Ref 2241.corr.RVBC260619

2241 Winkley Hall Farm, Whalley Road, Hurst Green , BB7 9PN

Application references 3/2026/0094 and 0095

1 Typical gable wall and truss partition
Scale: 1:20

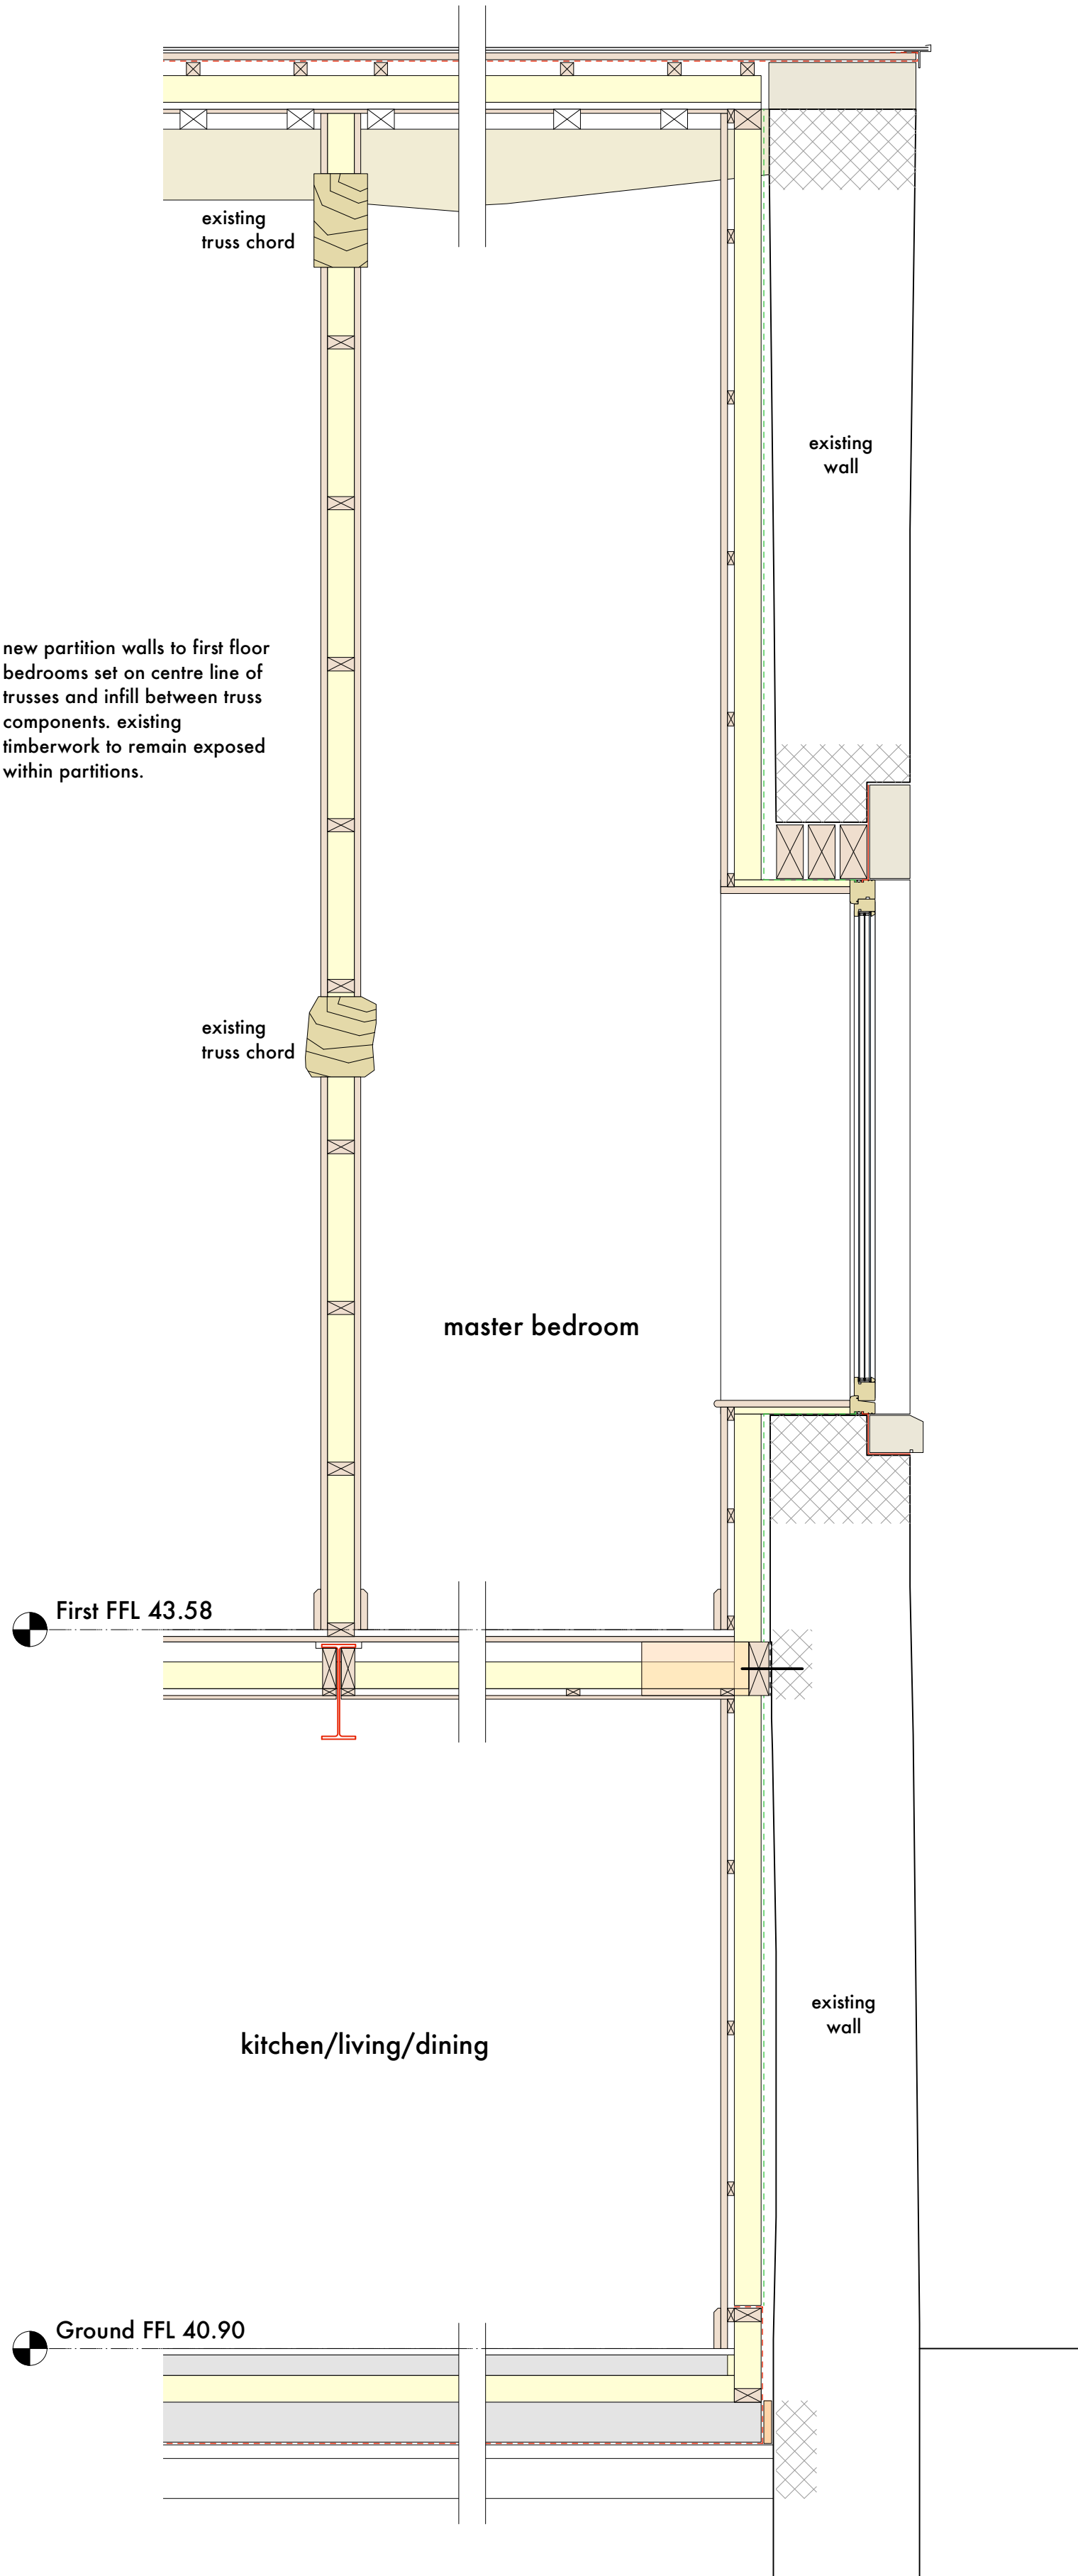
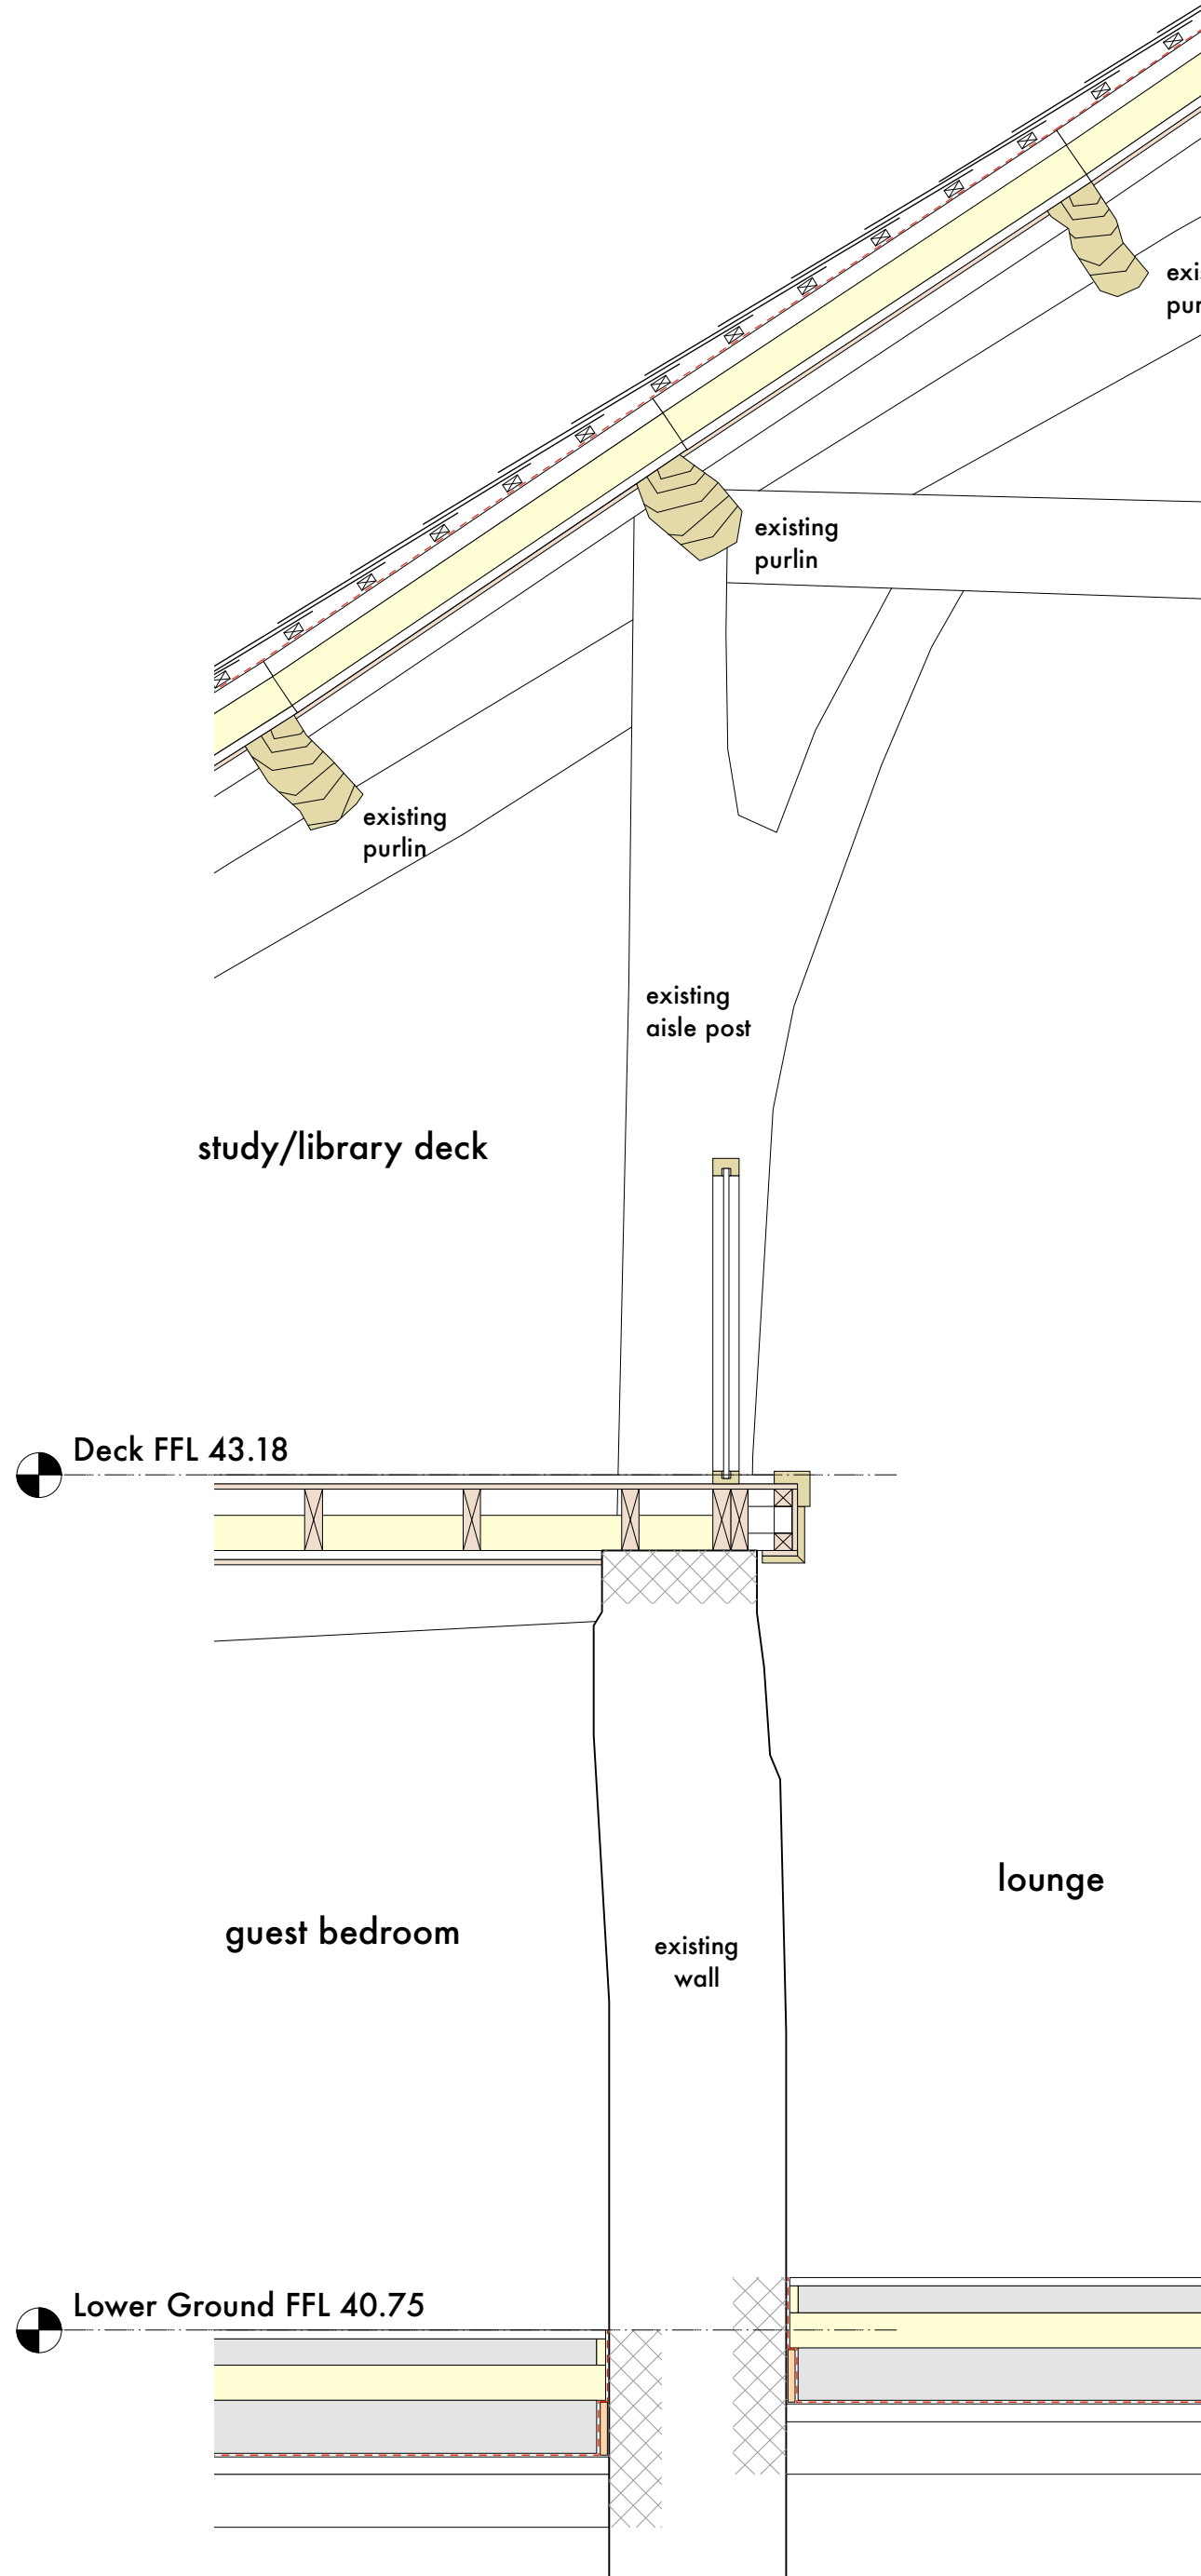
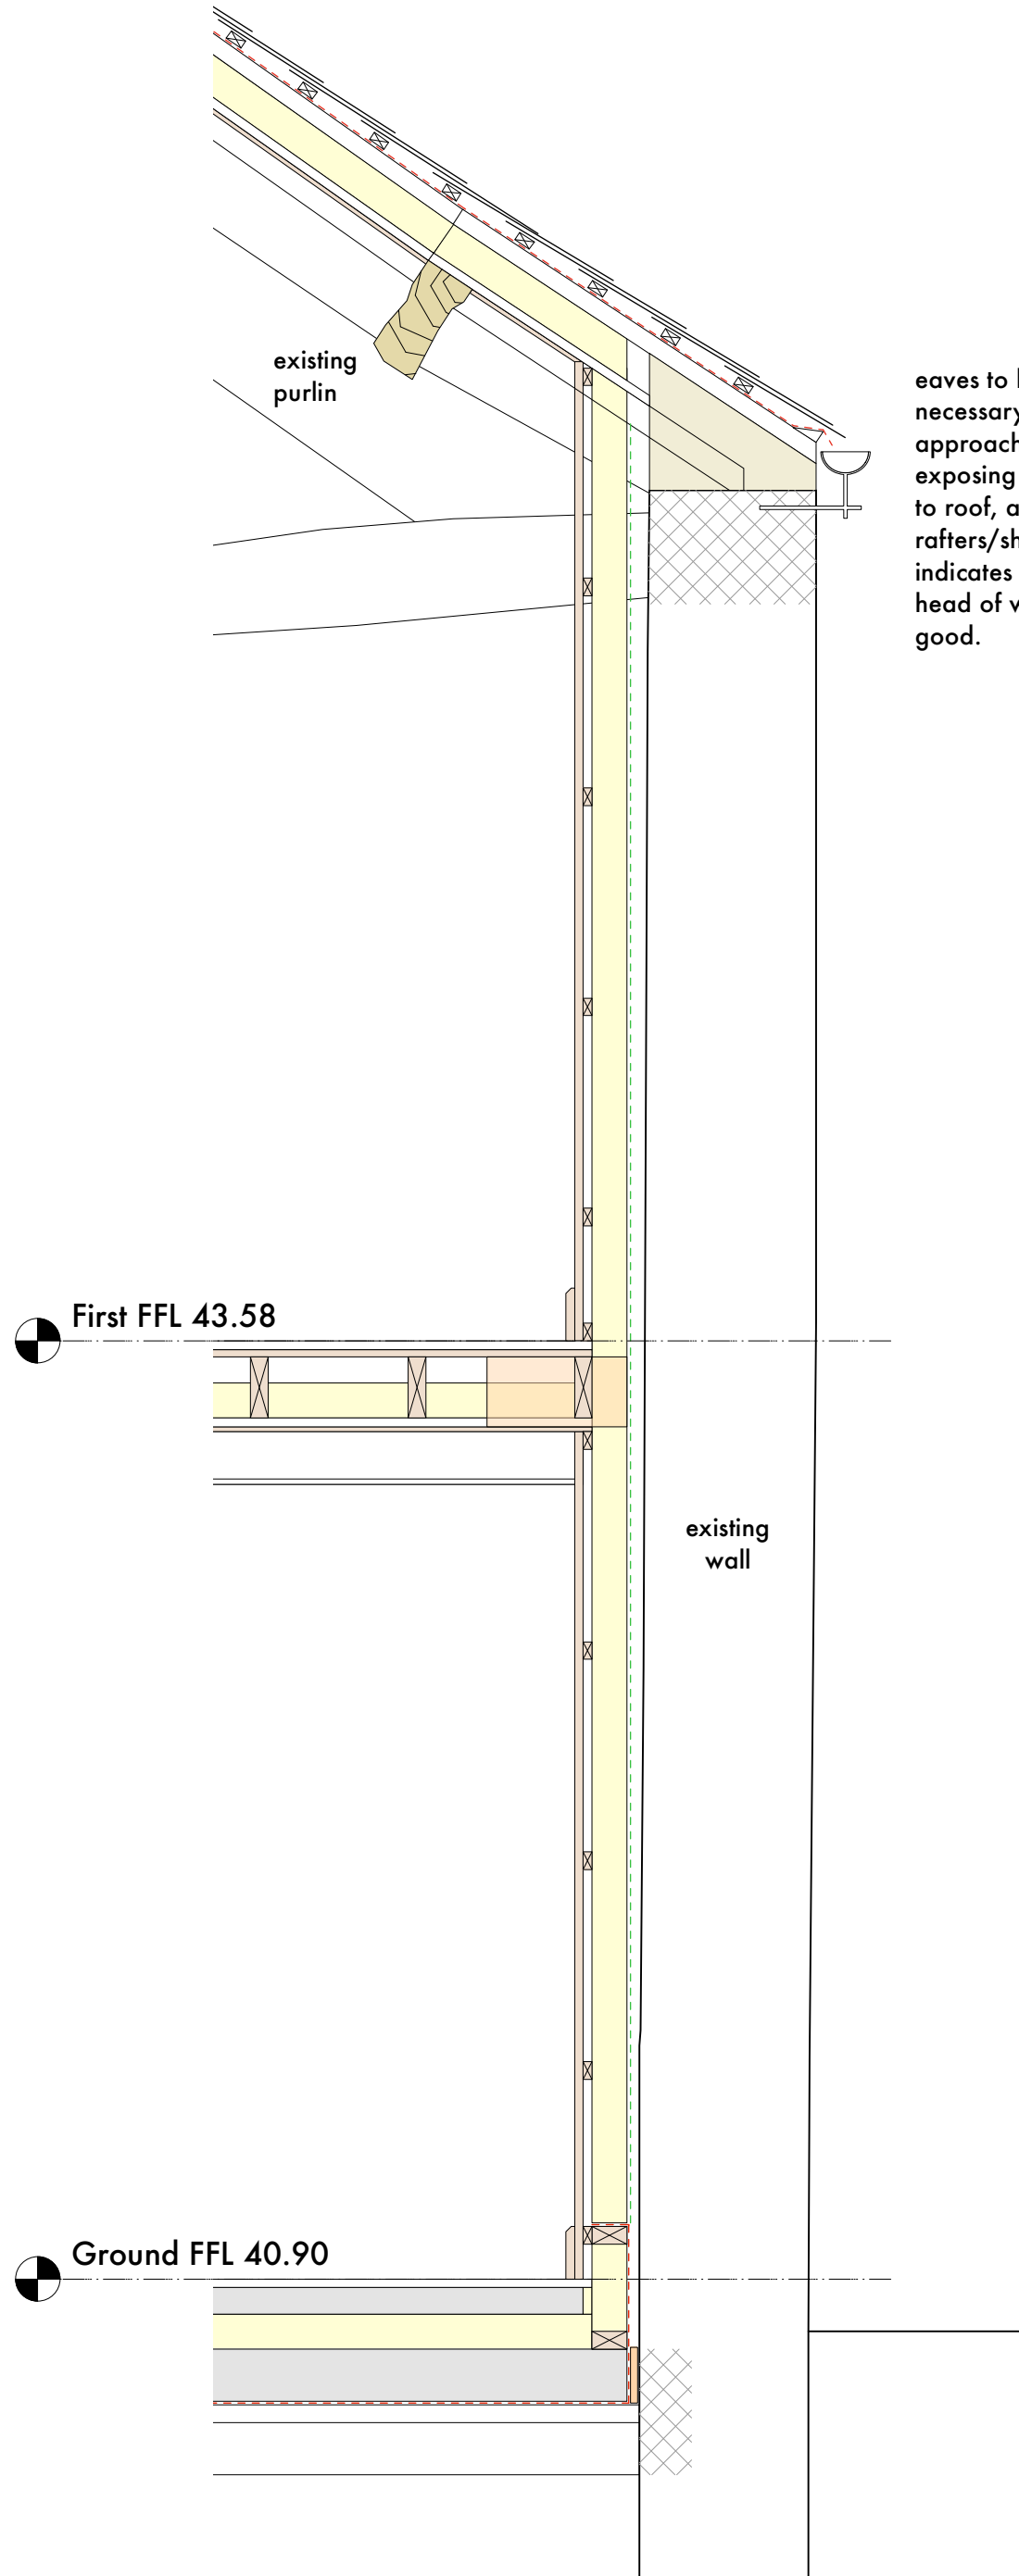
12. All floors are to be replaced with an insulated slab. The existing stone slabs to the threshing floor of the Main Barn are to be carefully lifted and re-used as part of the proposed floor finish. Illustrated to 111, 117, 118 and 120.

19. Full wall, floor and roof specifications included to 120 (Main Barn) & 220 (Barn 2). Independent stud linings proposed for walls to avoid disturbances to historic fabric where possible. Roofs will be insulated from above, leaving existing timbers (trusses, purlins, rafters etc) exposed internally.
